REQUEST

Current Zoning: B-2 (general business)
Proposed Zoning: MUDD(CD) (mixed use development, conditional)

Approximately 5.65 acres located along the east and west side of Charlotte Park Drive, south of Pressley Road, and west of Interstate 77.

The petition proposes a multi-family development with up to 210 units and up to 4,000 square feet of non-residential uses on parcels that are currently vacant.

TECHNICAL DATA SHEET
PET. NO. 2022-179

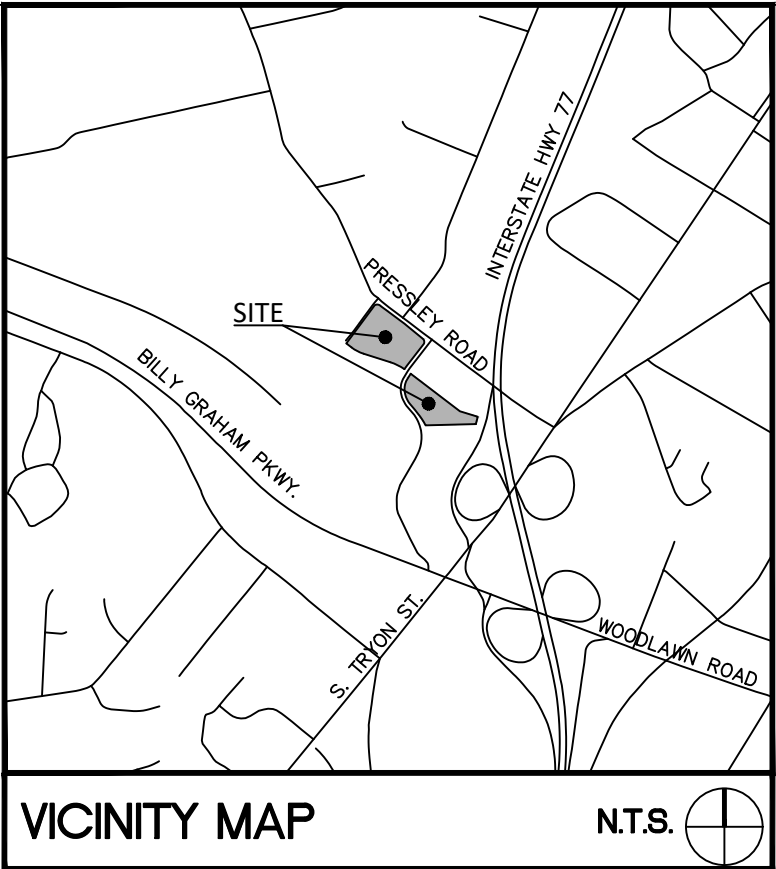
1. Commit to the installation of an ADA-compliant bus stop along route #12, at the corner of Pressley Road and Pioneer Park Drive.
2. Complete a Comprehensive Transportation Review utilizing Tier 1 standards for medium to high intensity development, as found in the Charlotte Streets Manual.

3. Reduce the proposed maximum building height to 65'.

4. Under note a in Permitted Uses revise the wording to say, "personal service uses" rather than, "person service uses."
